From: Barker, Francesca (NE) [REDACTED]
Sent: 15 January 2014 10:35
To: Planning.Responses
Subject: FAO: Simon Davis URGENT
Importance: High

Further to our telephone conversation today, regarding an amendment to the recently submitted planning application for a new boat ramp at Bognor Yacht Club.

Amended condition 1.

LOCATION PLAN 'ISSUE C'

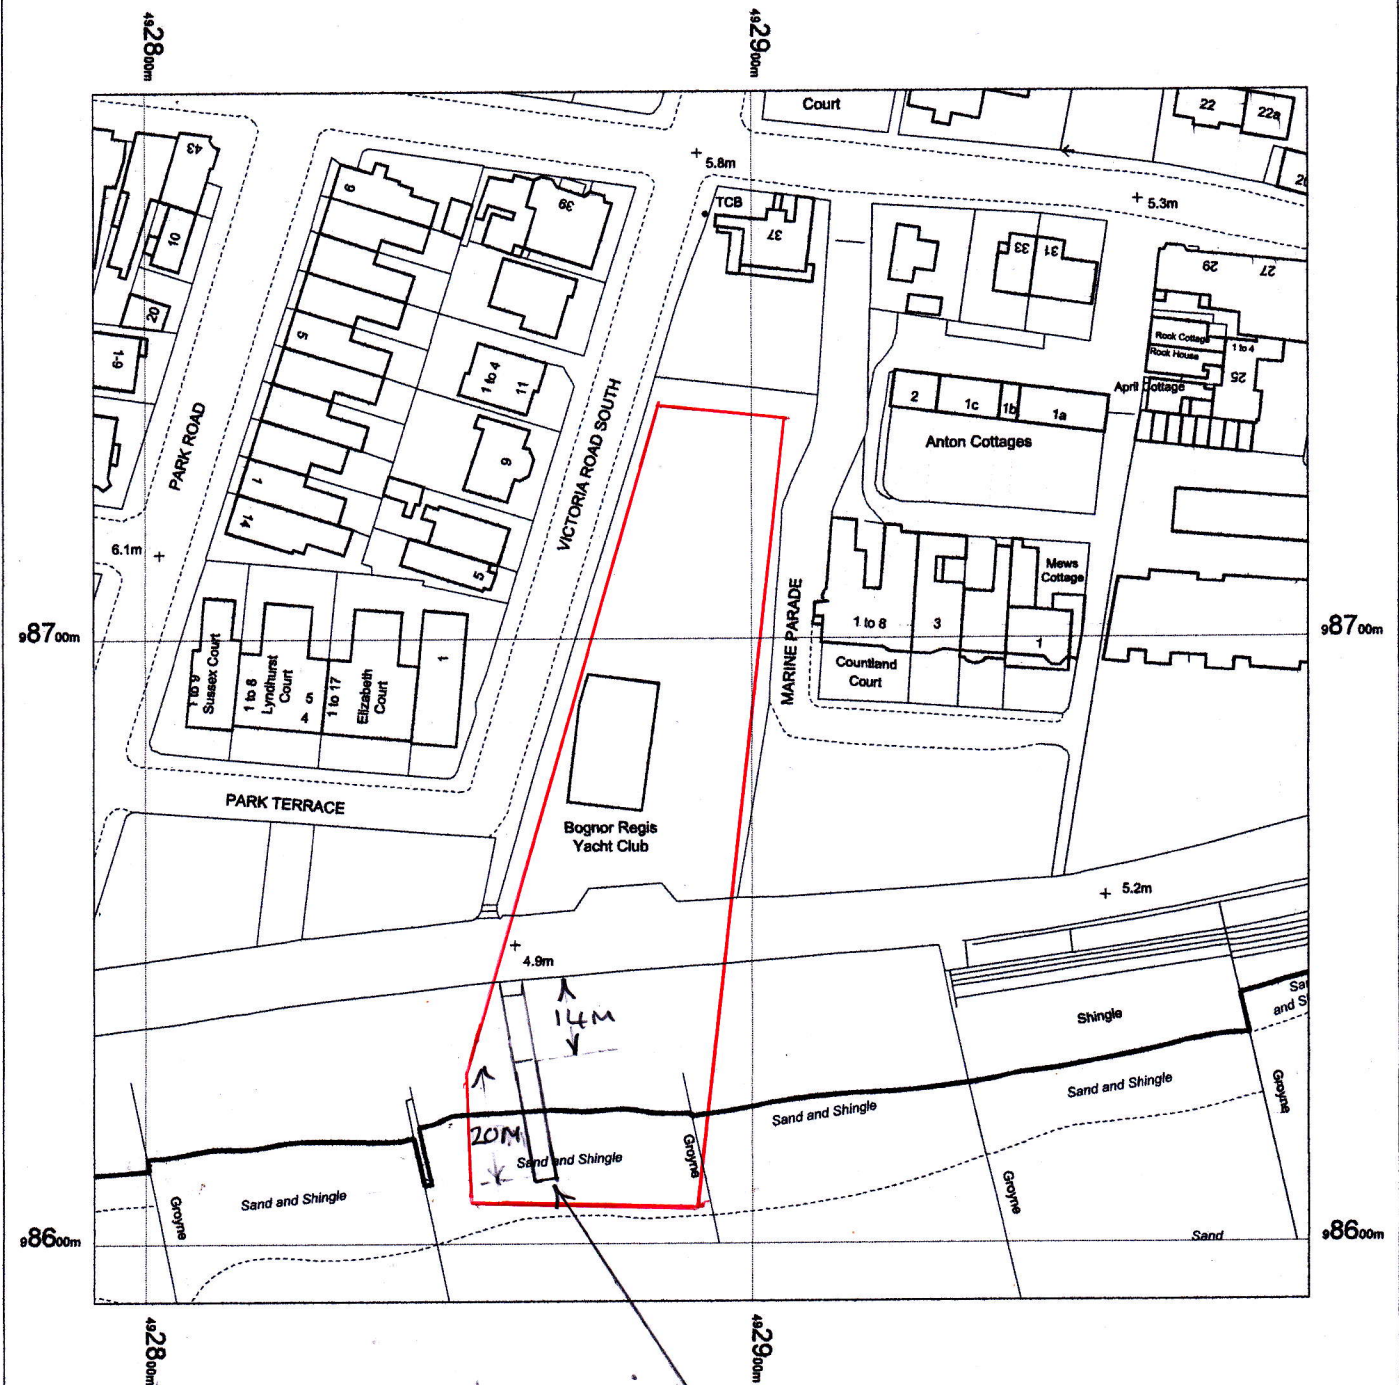
The amendment requested is to extend the ramp so that the sloping section of the ramp measures 22 metres not 21 metres as originally specified. This will mean it extends 1 metre beyond the end of the nearby outfall pipe. The straight section will remain at 14 metres to clear the stable part of the shingle beach.

1. The ramp is to extend no further than 1 metre seaward of the nearby outfall pipe (see photo in annex 1) in order to avoid impacting the movement of natural sediment.

I can confirm that this small extension is acceptable. All other conditions are to remain the same.
